CITY OF ALBUQUERQUE

January 22, 2014

Re: Platinum Apartments, 4100 Silver Ave, Traffic Circulation Layout
Architect's Stamp dated 01/20/13 (K17-D108)

13012
AS103

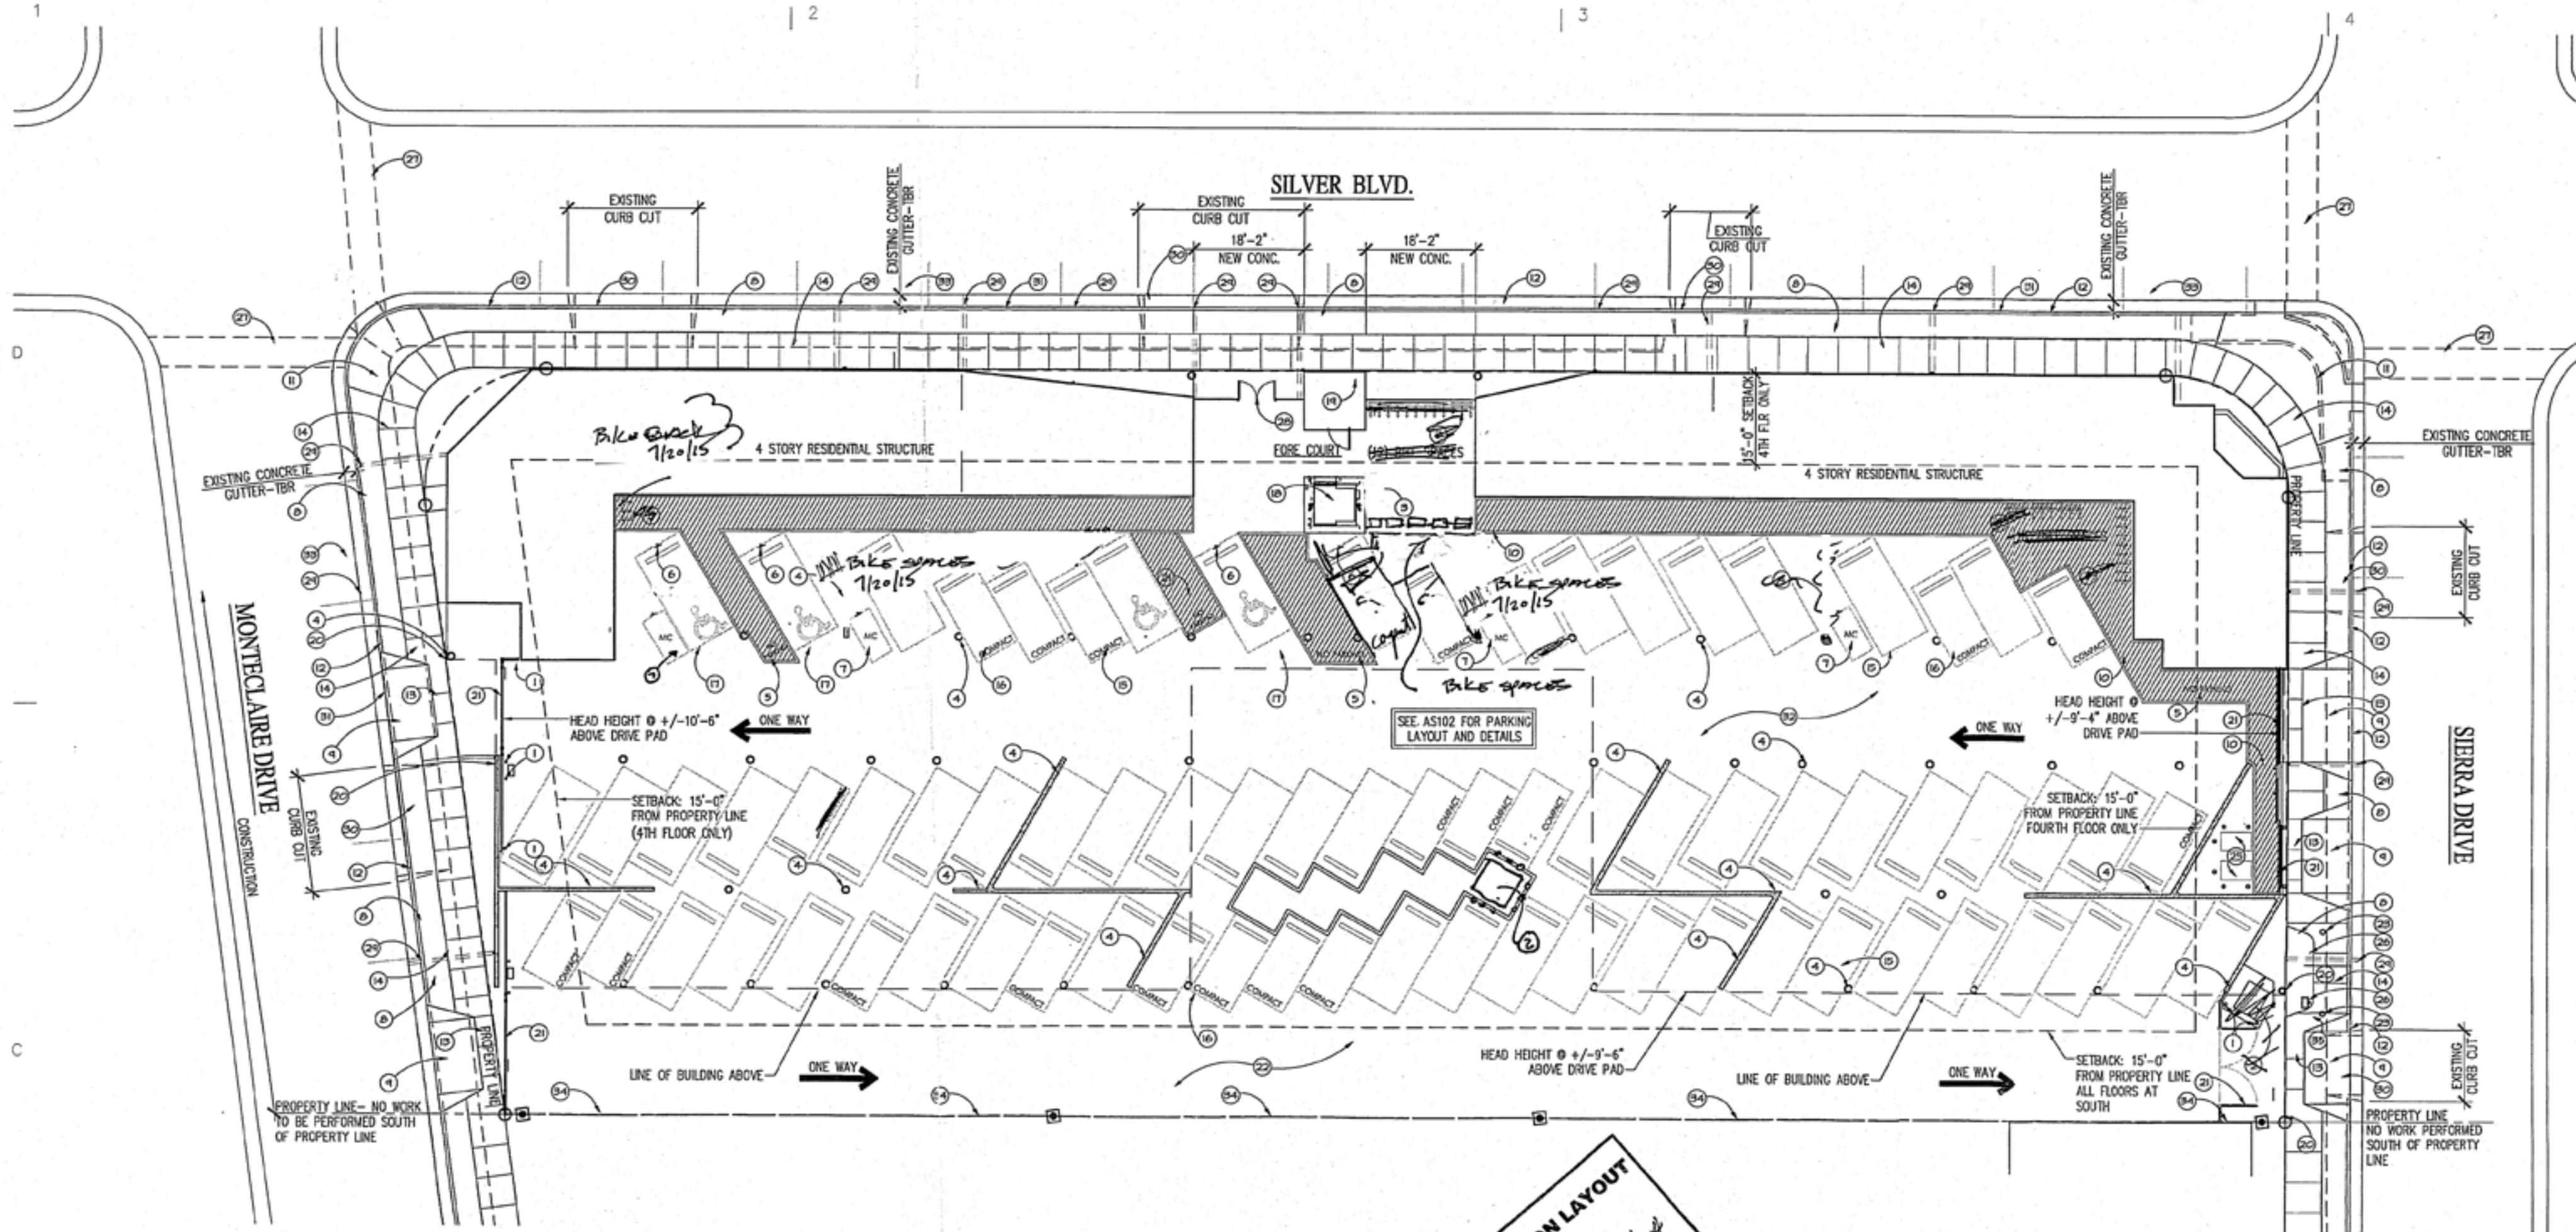
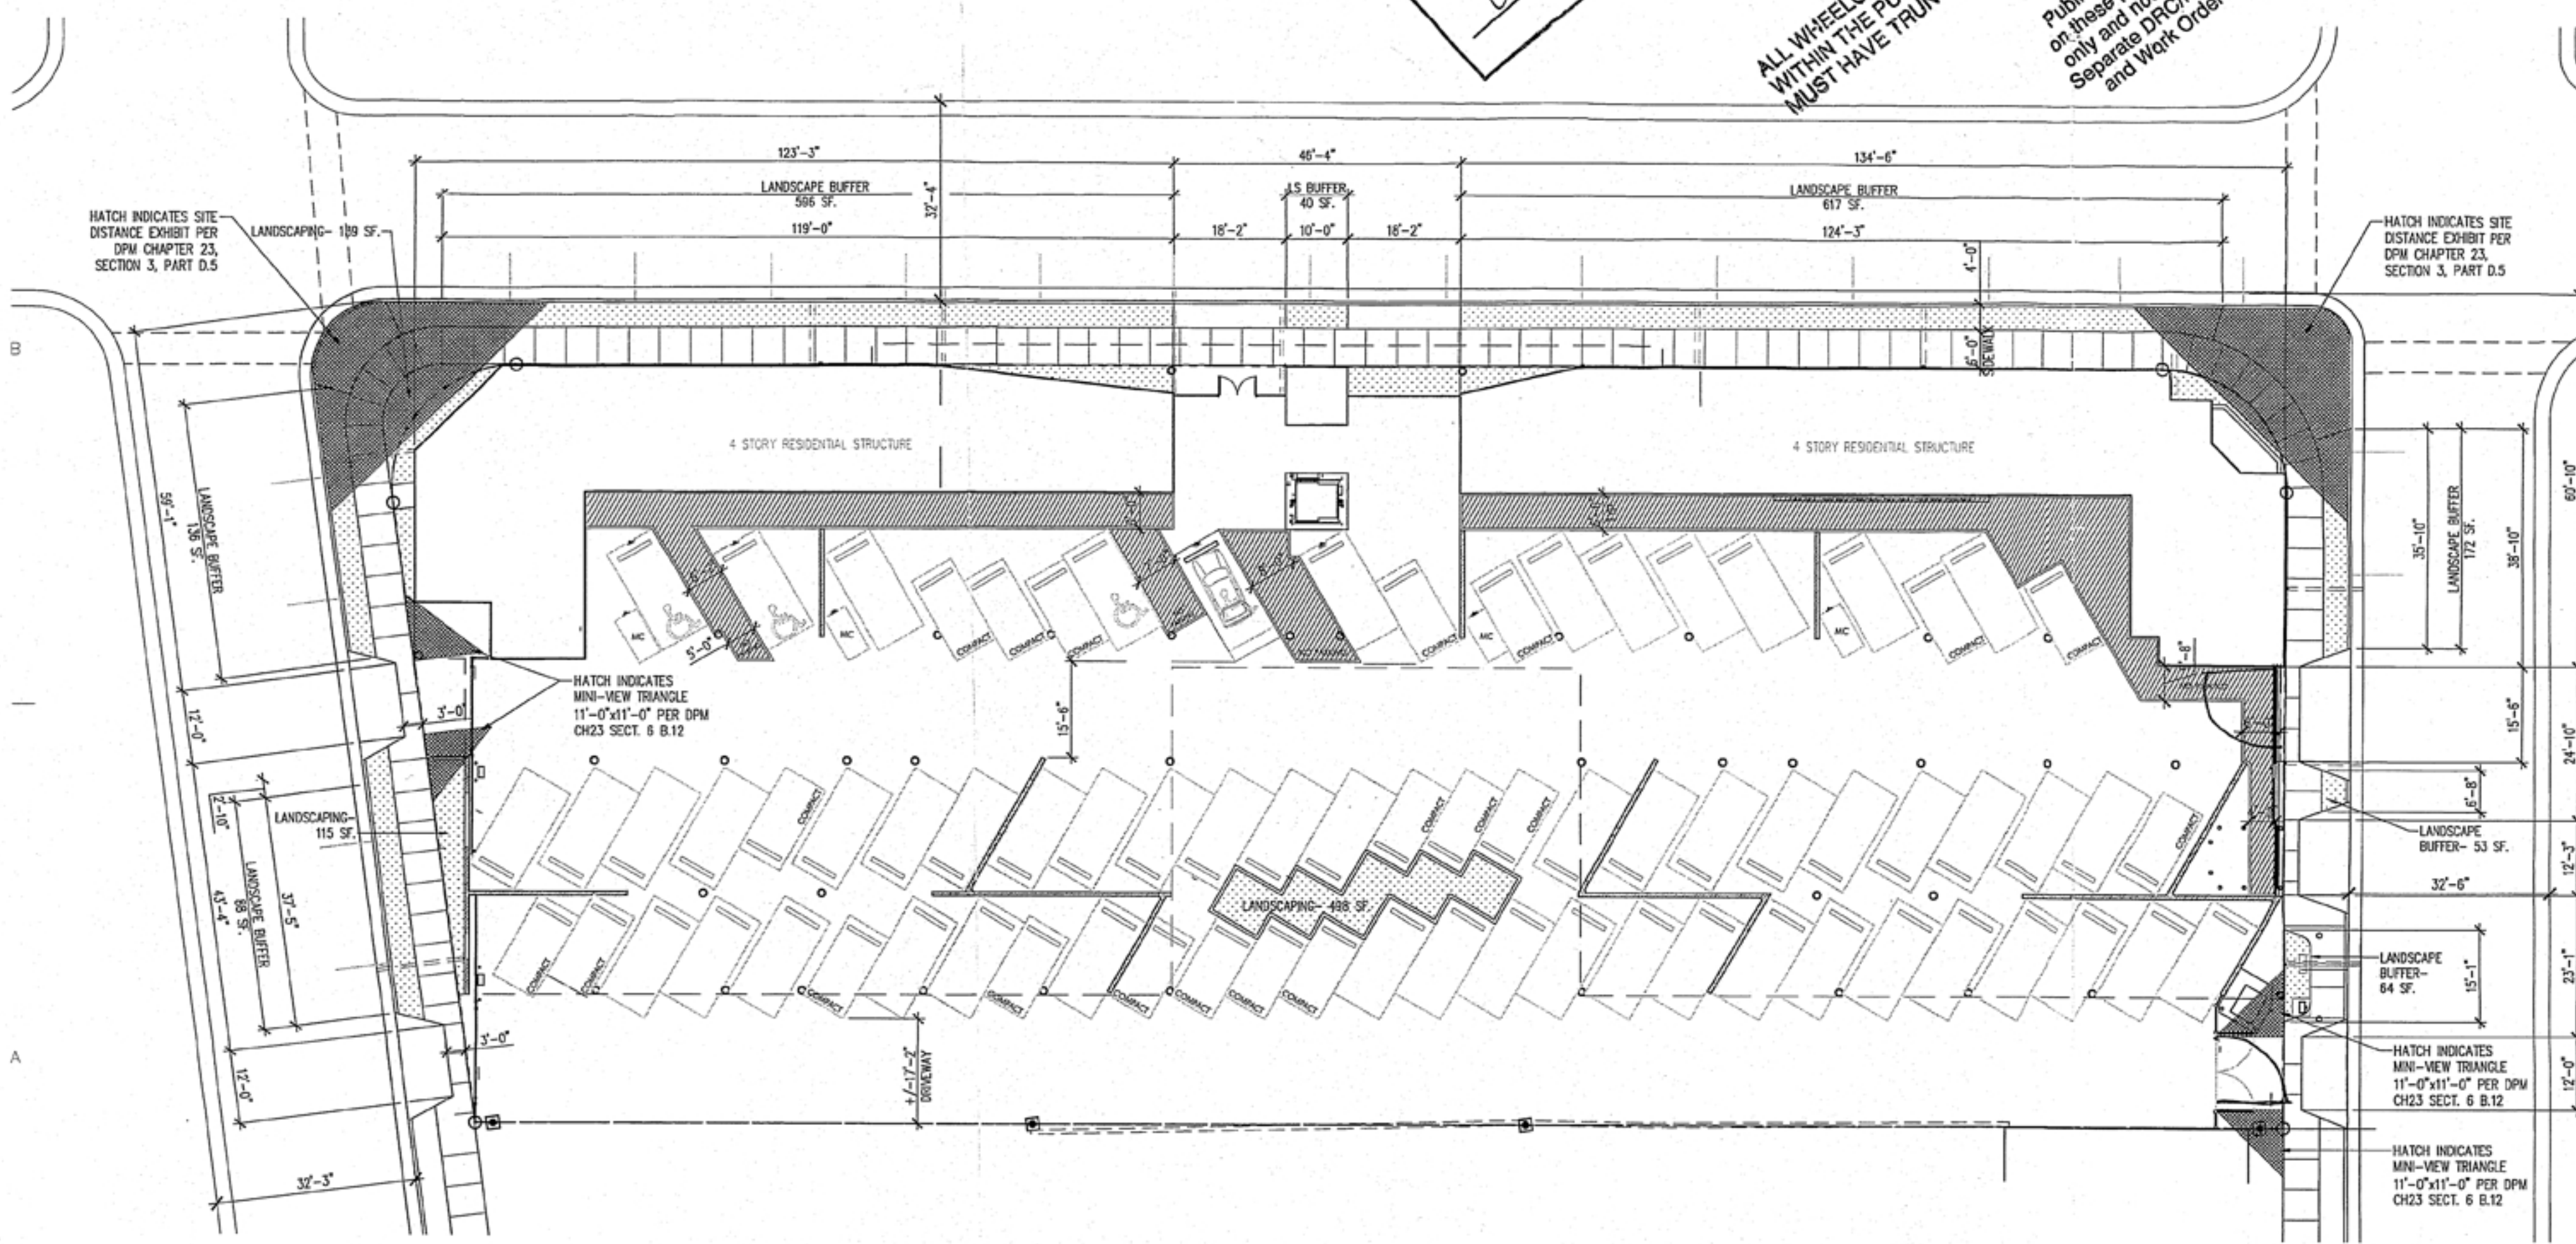
1. Demonstrate the proposed building location will not interfere with the sight distance of the intersection. Please provide a sight distance exhibit (see the *Development Process Manual, Chapter 23, Section 3, Part D.5 Intersection Sight Distance*).

2. Demonstrate the "mini clear sight triangle" is maintained at proposed driveways (see *DPM Ch 23, Section 6 Curb Cuts and Drivepads, part B.12 Visibility for Driveways*).
3. Please add the following note: "Landscaping and signing will not interfere with clear sight requirements. Therefore, signs, walls, trees, and shrubbery between 3 and 8 feet tall (as measured from the gutter pan) will not be acceptable in this area."
4. On-Street parking Allowance to fulfill zoning's parking requirement must be approved by the Traffic Engineer, Kristal Metro prior to TCL approval. The application requires 15 working days. On-street parking allowances are based on available parking along public right-of-ways fronting the

5. Recommend maintaining existing intersection corner layouts to avoid a COA Work Order to patch street asphalt.
6. Clarify Key Note 31 (for example, remove existing infrastructure and replace with curb & gutter, sidewalk or landscape buffer as indicated).
7. Remove Key Note 27; this is COA Street Maintenance jurisdiction.
8. Please check the dates submitted; I believe the architect's date is incorrect.
9. Please correct minor labeling errors discussed over the phone with Ken Myers. The submitted site plan with mark-ups is available to borrow. Please return this site plan with next submittal.
